**West
Northamptonshire
Council**

Other Authority Consultation

To: Cherwell District Council C/O Cherwell District Council Chris Wentworth Cherwell District Council Bodicote House Bodicote Banbury OX15 4AA	CDC reference: 23/03428/OUT
	WNC reference: 2023/8096/OAC
	Application Date: 19 December 2023
	Date of Decision: 22 nd April 2024

Outline planning application for the construction of up to 140,000 sqm of employment floorspace (use class B8) with ancillary offices and facilities and servicing and infrastructure including new site accesses. Internal roads and footpaths, landscaping including earthworks to create development platforms and bunds, drainage features and other associated works including demolition of the existing farmhouse

FIGURE 4: PARAMETER PLAN

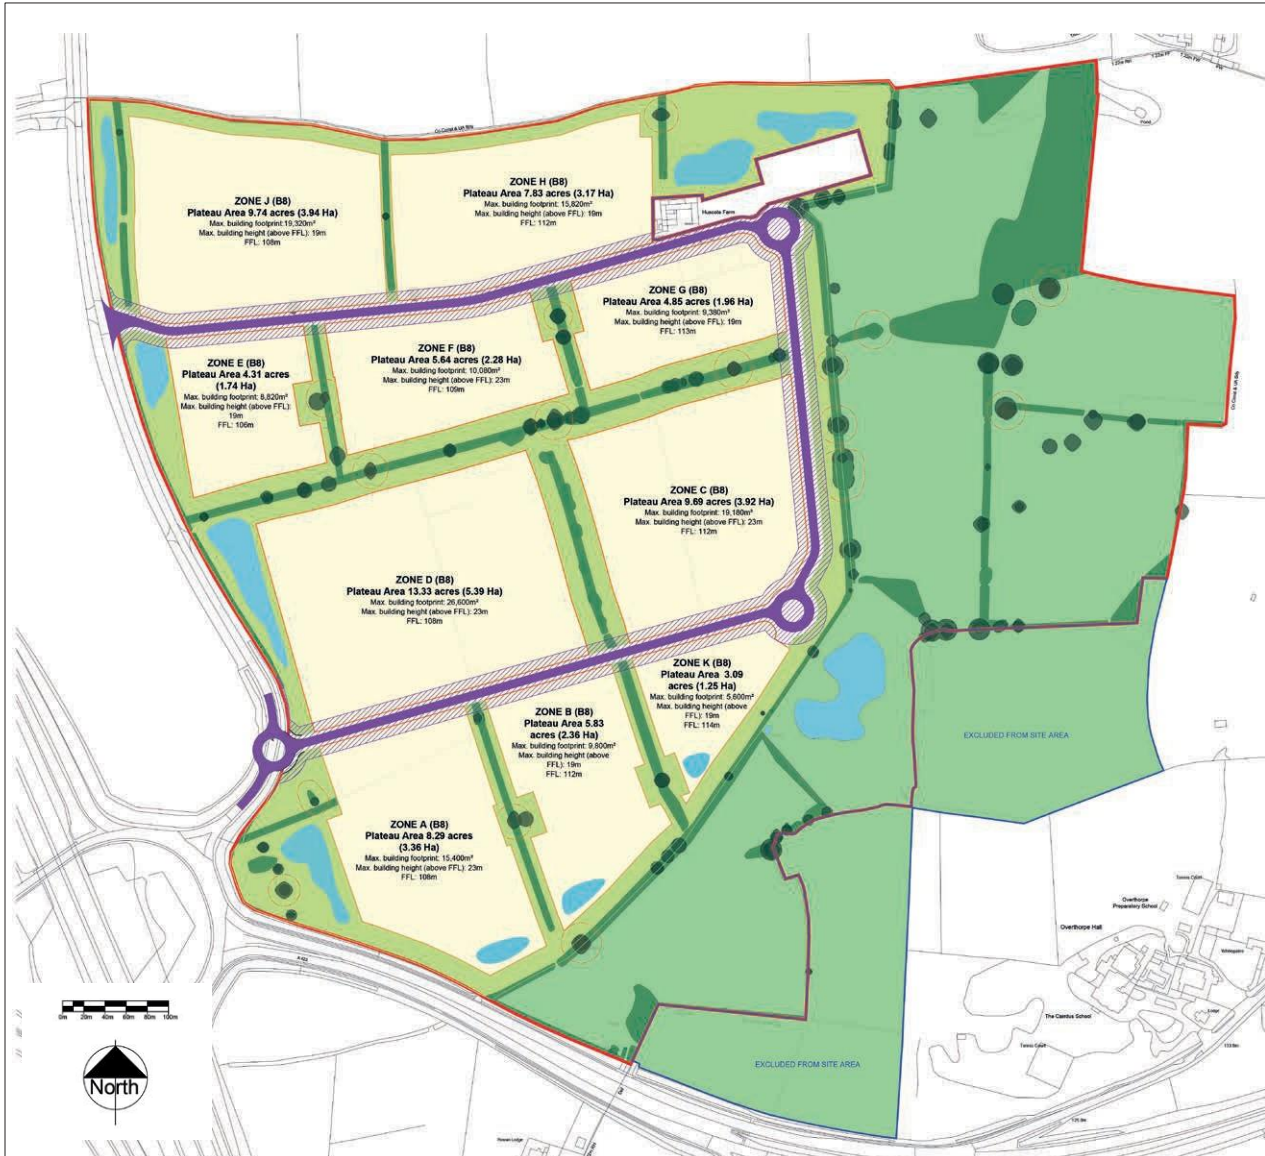
Approximately half the site would have a maximum height parameter of 23m. The remainder, including the plots predominantly around the site's northern and eastern edges, would have a maximum height of 19m. Whereas extensive landscaping is proposed to the eastern and south-eastern parts of the site, where the land starts to rise up to the escarpment, only a relatively narrow line of additional woodland planting is proposed to the northern boundary. No bunding appears to be proposed.

The LVIA does not provide any wireframe images to show how visible the development could theoretically be. Whilst landscaping is a reserved matter in this case, it is considered that the LVIA fails to demonstrate what the visual impacts of the development within the open countryside to the north of the site would be and how well they could be mitigated. WNC's concern is that the impacts would be 'moderate adverse', or even 'major adverse' in some instances, and that the indicative landscaping would not have meaningful effect on mitigating that impact, even in the longer term (15+ years post-construction).
